TO:	Helen Donaldson, Sr. Planner	DATE:	11/8/2018
FROM:	Michael Guethle, PE; Ryan Wingard, PE	PROJECT NO.:	13982C
SUBJECT:	Gilman St. - 22; MMC Parking Building (PL-000331-2018)

Wright-Pierce has reviewed the Level III Site Plan Application information provided for the Congress Street Patient Care Building proposed at 22 Gilman Street. The project will include redeveloping an existing parking garage into 64 modern patient rooms and 19 procedure rooms.

DUCT BANK SCHEMATIC

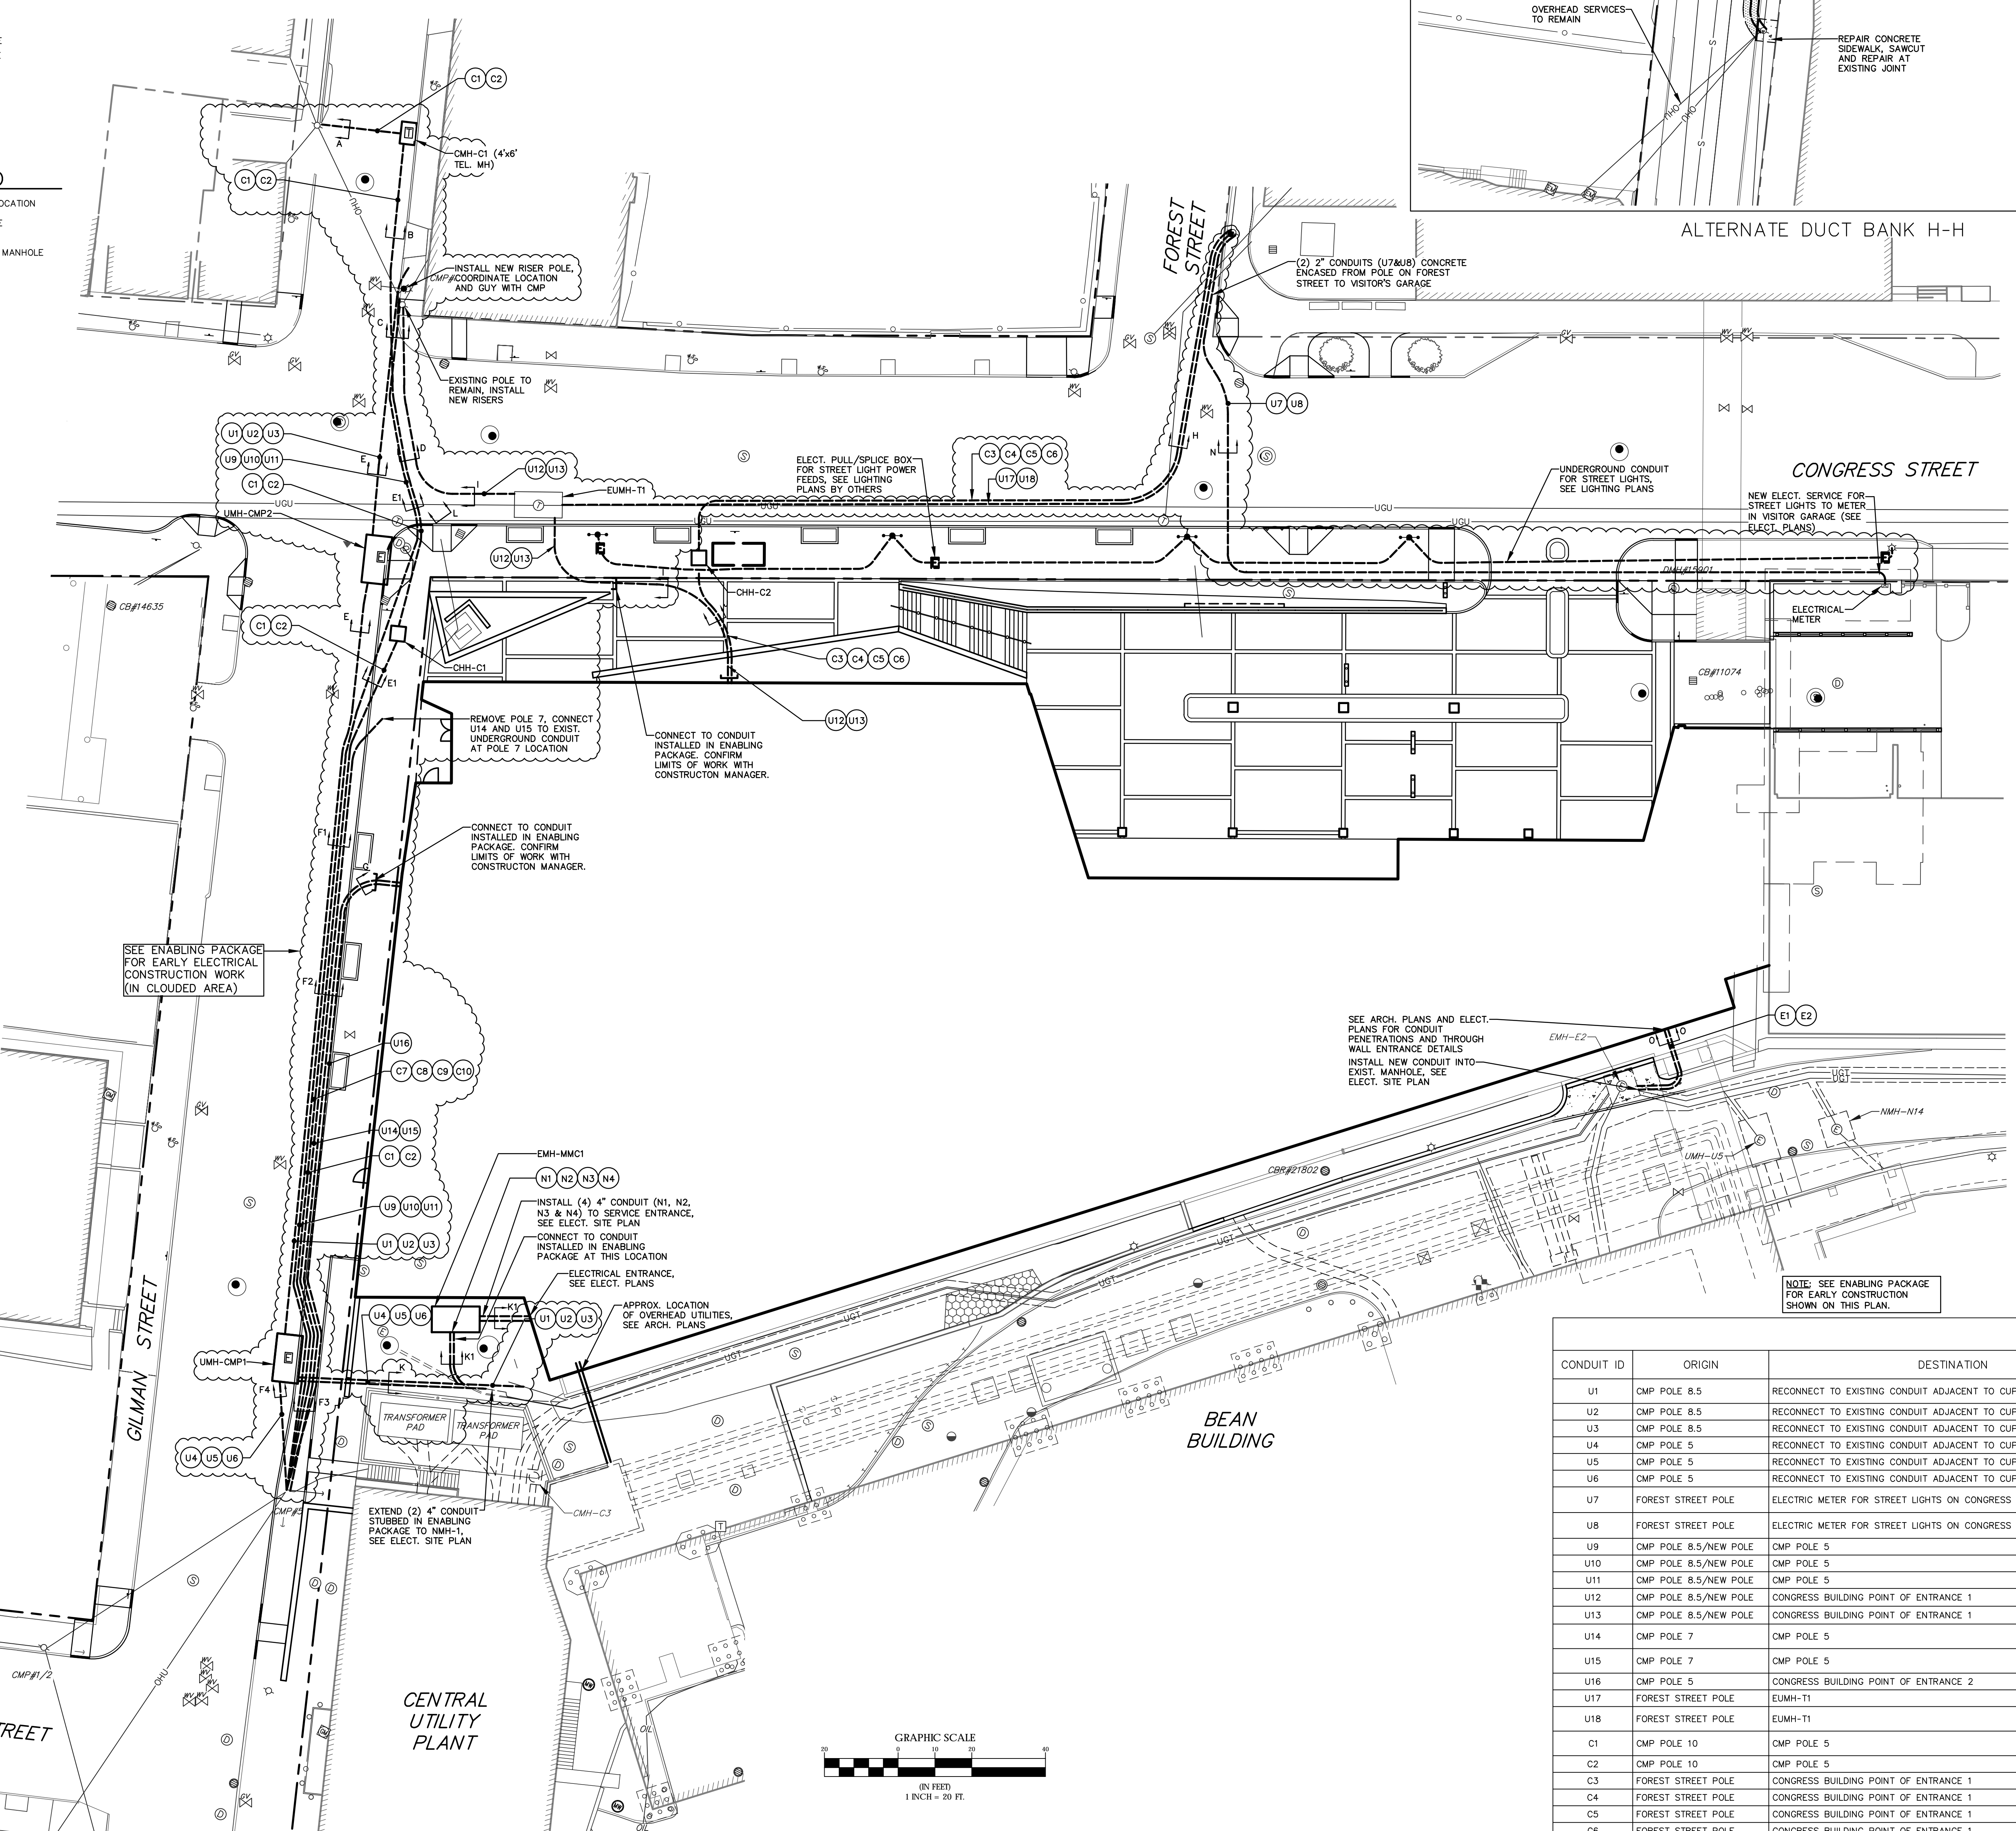
- a. Electrical and Communications Infrastructure
 - i. Electrical and Communications manholes, pull boxes, and duct banks are proposed. Details were provided for utility manholes. Utility duct bank details were not observed on the proposed details. Please provide information or details on duct bank size and material; and approximate duct bank elevations in locations where utility crossings are proposed.

TITLE
DETAILS
STORMWATER SYSTEM
CONGRESS STREET
EXPANSION

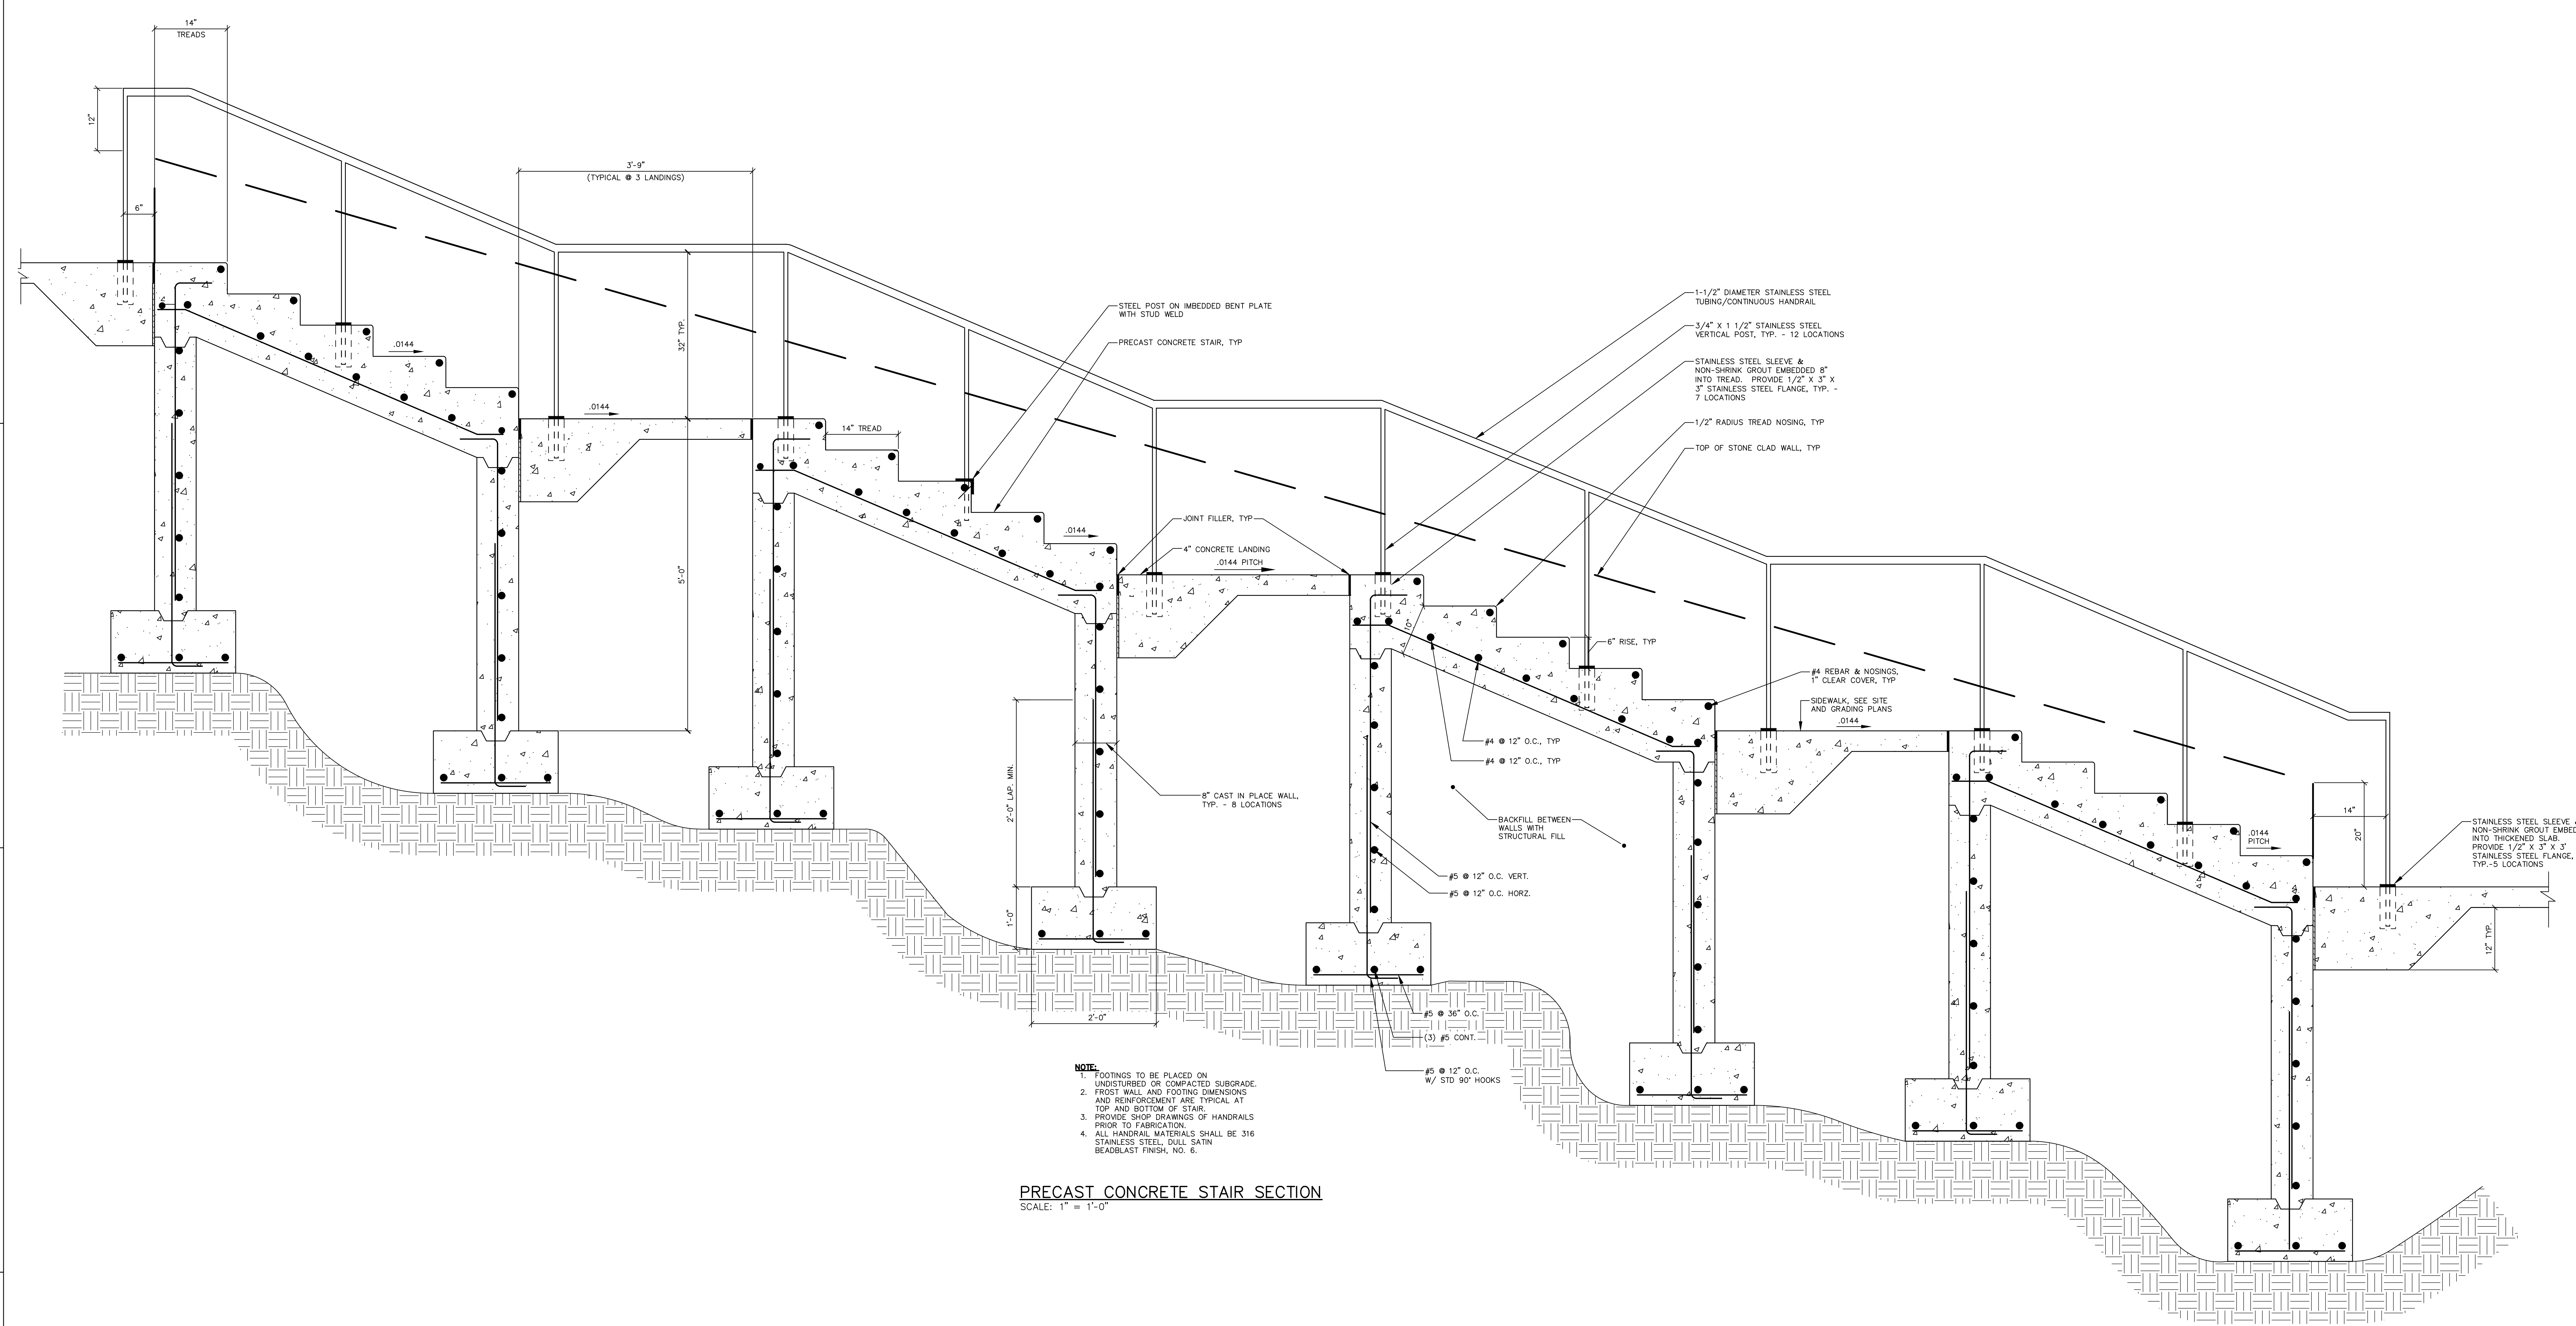
- b. Isolator row detail on C30-04 indicates a 12" maximum inlet pipe. Please confirm with manufacturer if this inlet is large enough facilitate maintenance/cleaning access to the isolator row.
